**From:** [Hendricks, Nancy E](#)  
**To:** [Kevin Patton](#); [Margaret Callahan](#); [Serina Gallegos](#)  
**Cc:** [Yolanda Padilla Moyer](#)  
**Subject:** Re: [EXTERNAL] Perimeter Fencing along the National Park Service and APS Boundary  
**Date:** Monday, May 12, 2025 12:34:17 PM  
**Attachments:** [Outlook-ulpqnxeb.png](#)  
[Outlook-1amqnvin.png](#)

Thanks for sharing the proposed fence and wall information with Petroglyph National Monument. We are in support of this type of fence as from an enforcement perspective, it would likely be decent at deterring trespassing which is beneficial for the Monument and for the community.

The enclosed pdf exhibit reflects a red line that is a view fence adjacent to the property line with the NPS and APS. The view fence is five to six feet high with metal fencing and timber posts (see enclosed pic). The metal fencing can be a rust color if you would rather have the rust coloring. The blue line is our rear perimeter fencing or wall that will be split face cmu block that looks similar to the perimeter wall that exists today on the community to the west. We are looking to flip the color possible. I've enclosed a screenshot showing that wal

PERIMETER FENCING ADJACENT TO THE PETROGLYPH NATIONAL MONUMENT SHALL BE 5'-6" STEEL WIRE MESH (HOG WIRE) ON WOODEN POSTS AS APPROVED BY THE NATIONAL PARK SERVICE TO MATCH THE EXISTING FENCE TO THE WEST ADJACENT TO THE INSPIRATION SUBDIVISION. POSTS SHALL BE SPACED 12'-15' O.C.

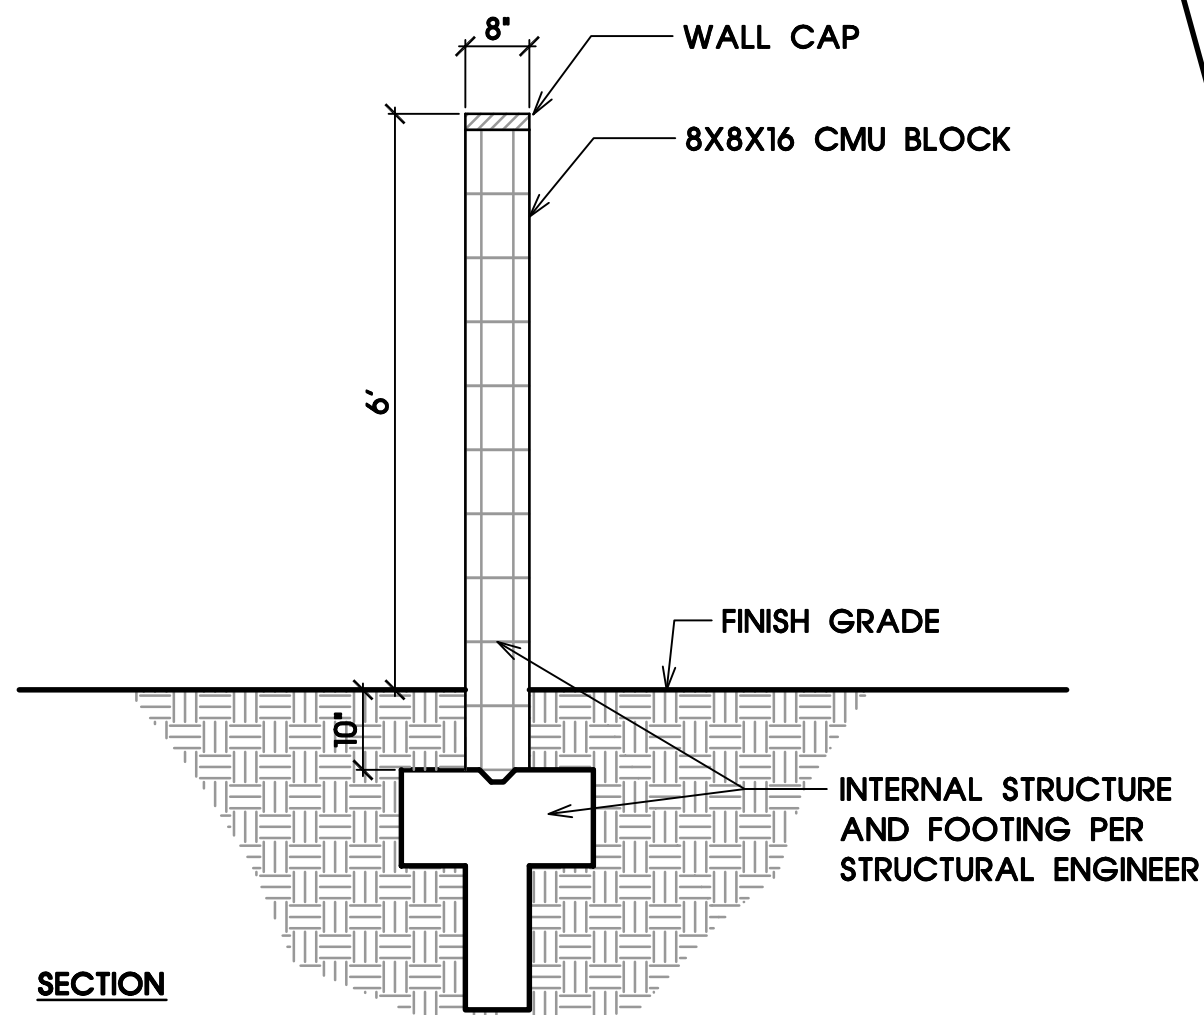
We would suggest installing the base of the fence around 3-4" above ground level so as not to trap small mammals. It's hard to see from the photos whether the openings in the fence would be large enough for small mammals and lizards to travel through, so installing the base slightly above the ground would allow small animals to get through without being trapped.

The less "shiny" the better as well - so that rust color may work well, or if the fence would fade/patina over time, that'd work as well.

Clarification - Once installed and once the Pulte project is completed, would the HOA/NA be responsible for long-term fence maintenance?
